Grading &
Drainage
2013075

Project Title: FedEX Ground City Drainage #: _____
DRB#: _____ EPC#: 14EPC-40012 (Project #1009982) Work Order#: _____
Legal Description: A portion of Tract 12, Tract 13, and Tract 14A, Town of Atrisco Grant Unit 5
City Address: Not yet assigned

June 11, 2014

**RE: FEDEX GROUND OVERALL GRADING AND DRAINAGE PLAN
RESPONSE TO COMMENTS**

ENGINEER'S SEAL RONALD R. BOHANNAN P.E. #7868	FEDEX GROUND ALBUQUERQUE, NM		DRAWN BY DY
	INTERIM GRADING AND DRAINAGE PLAN		DATE 7-3-14
	TIERRA WEST, LLC 5571 MIDWAY PARK PLACE NE ALBUQUERQUE, NM 87109 (505) 858-3100 www.tierrawestllc.com		2013075-GRE-INTERIM
	SHEET # GR-4		JOB # 2013075

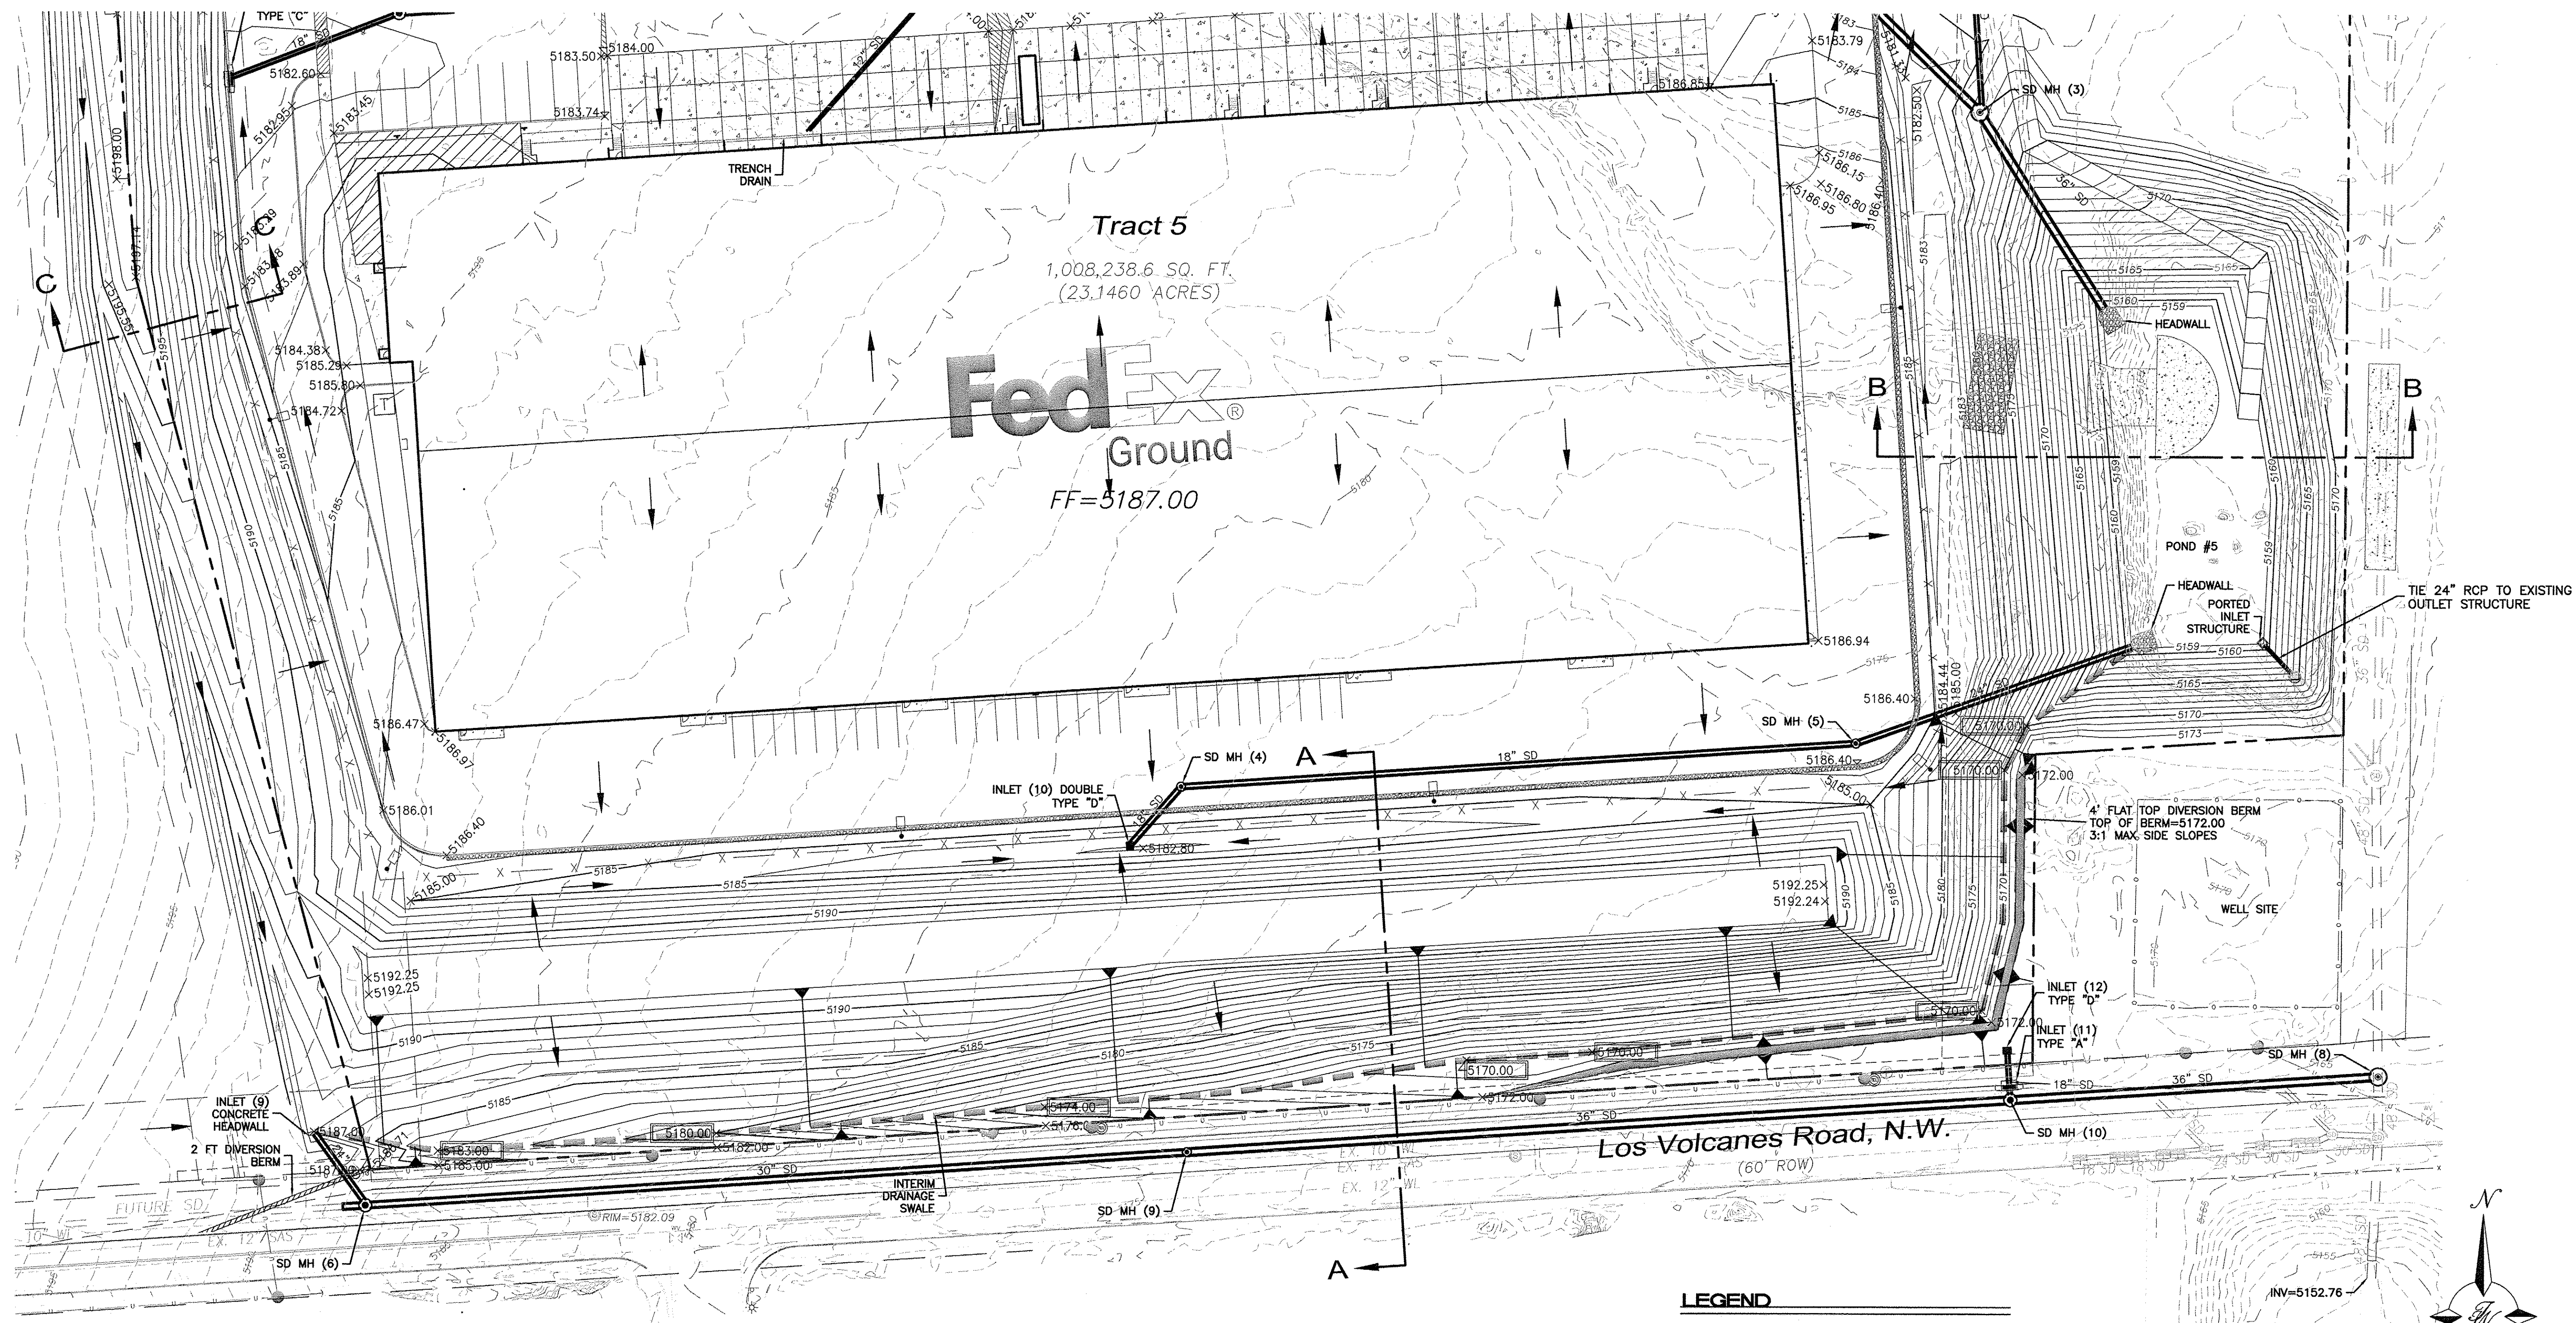
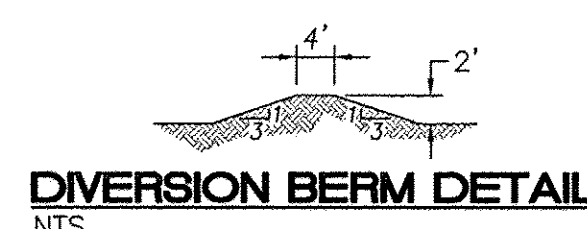
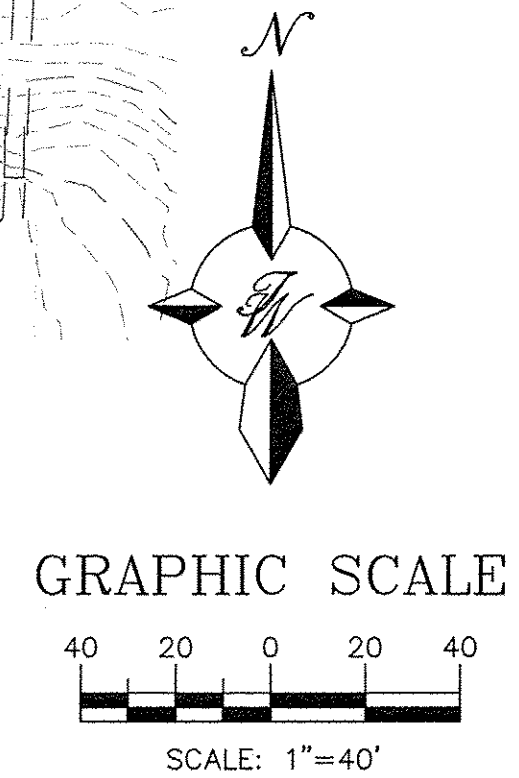
8. A small pond should be graded in the southeast corner of the site to contain flows prior to the construction of Inlet 12.
An interim grading plan has been provided with this letter to show diversion of the noted flows to Pond 5. Completion of the berm that is intended to screen the development from the residential subdivision to the south will be required upon installation of the proposed storm drain in Los Volcanes.

POND 5 OUTLET STRUCTURE MODIFICATION DETAIL
NTS

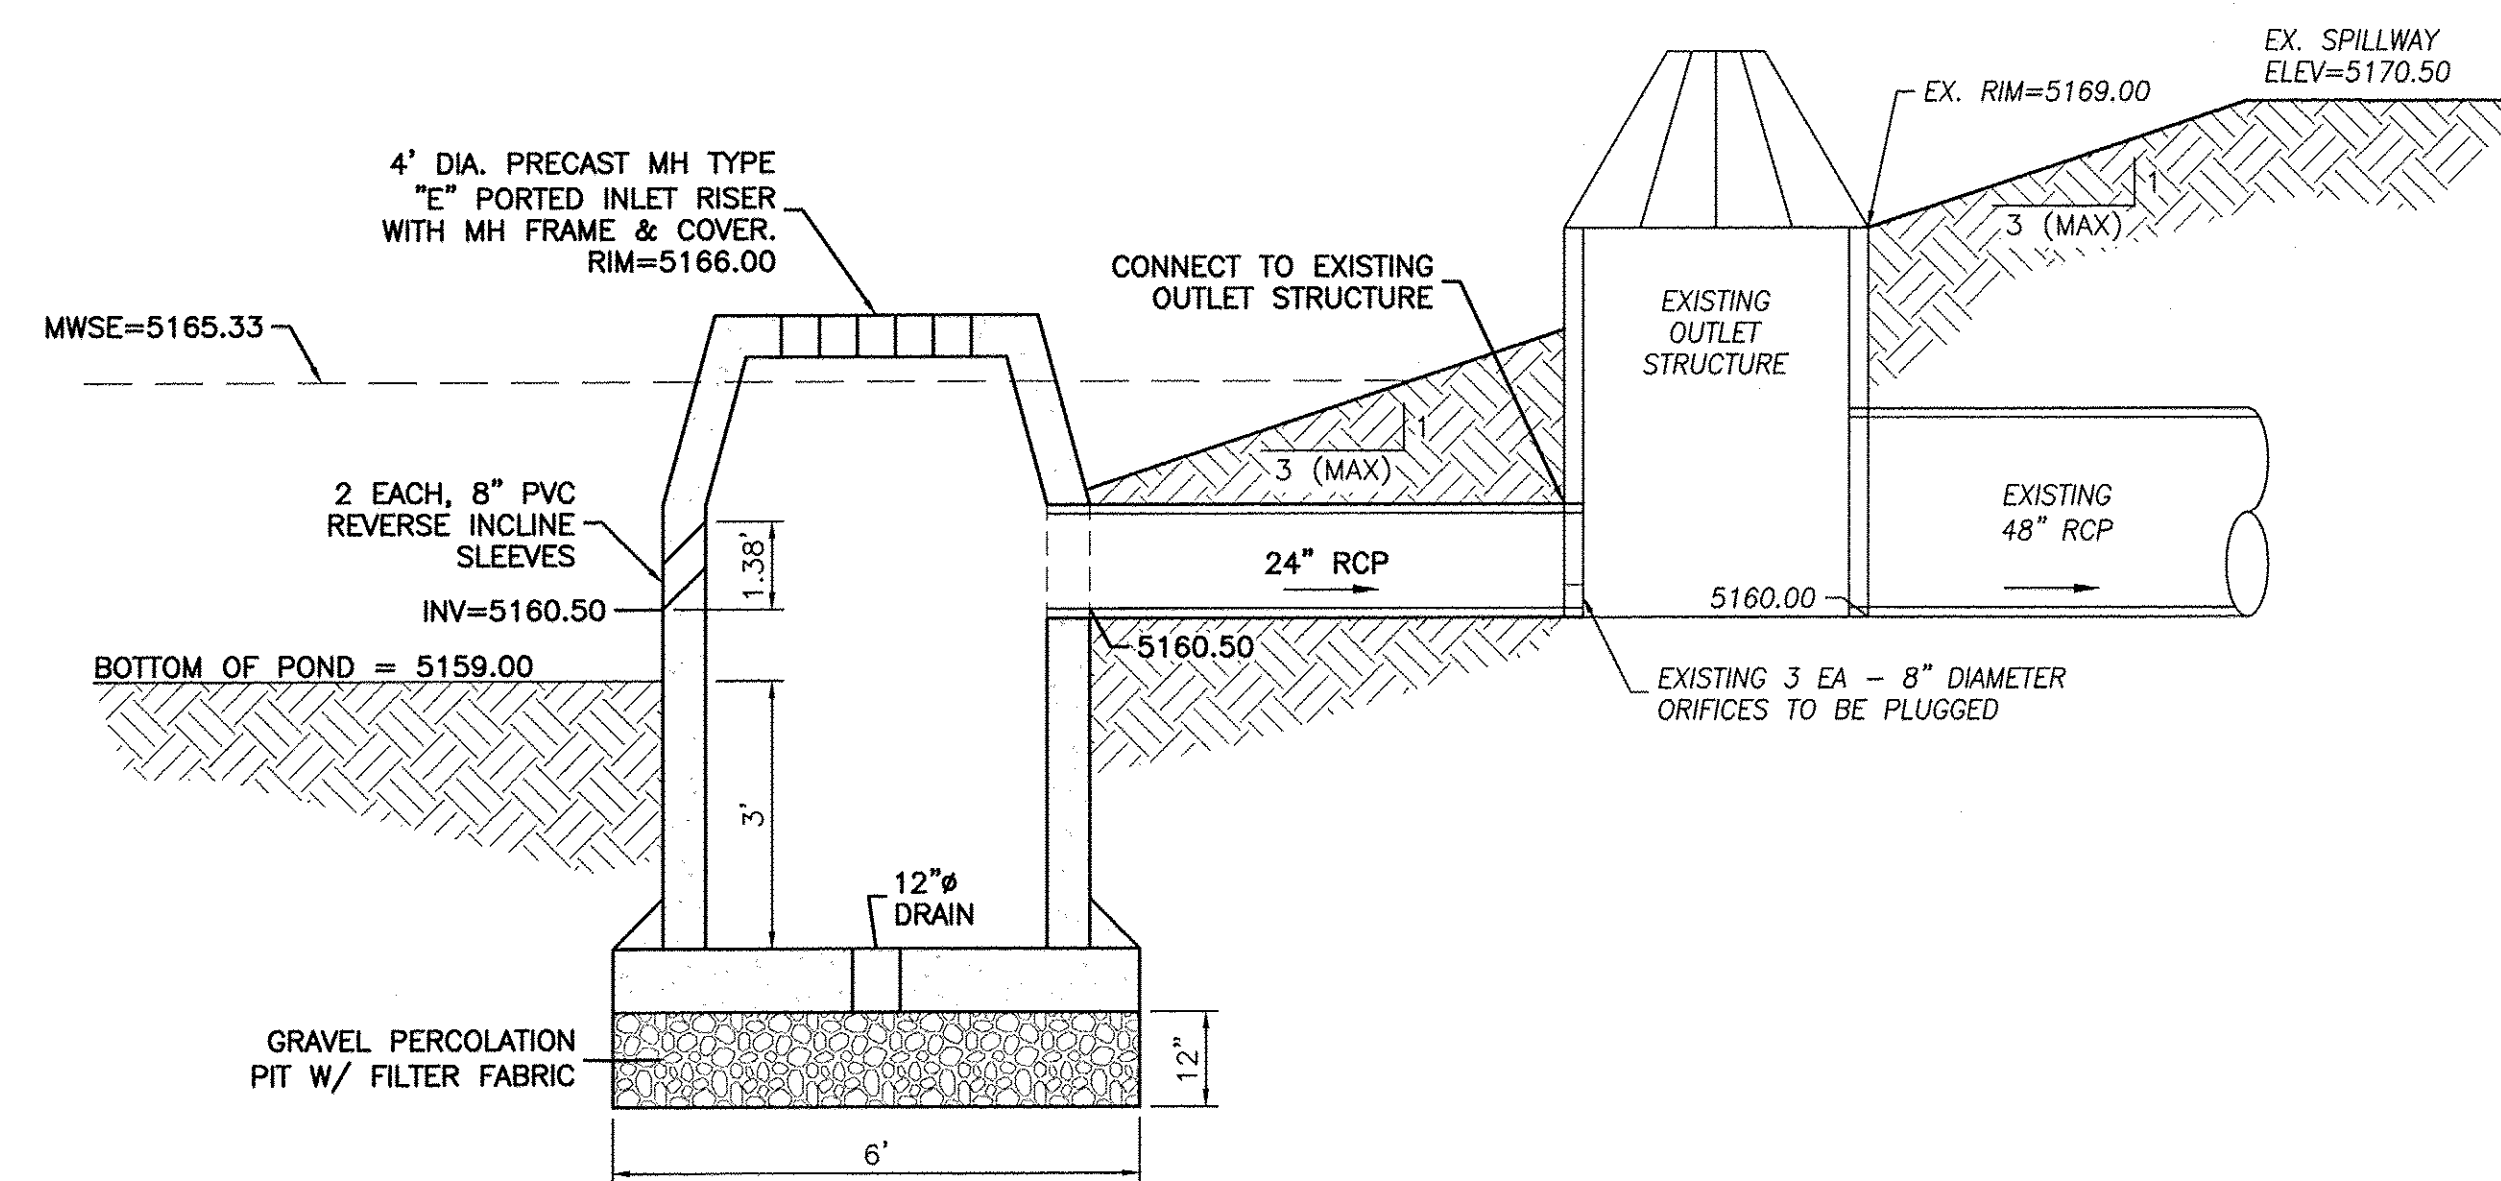
4. Is Pond 5 to be used for sediment control as part of the SWPPP? If so, will you be plugging the 3-8" pipes?
Yes, Pond 5 will be used in conjunction with proposed BMP's as part of the SWPPP. The existing primary and secondary outfalls will be protected from sediment leaving the ponding area but will not be plugged.
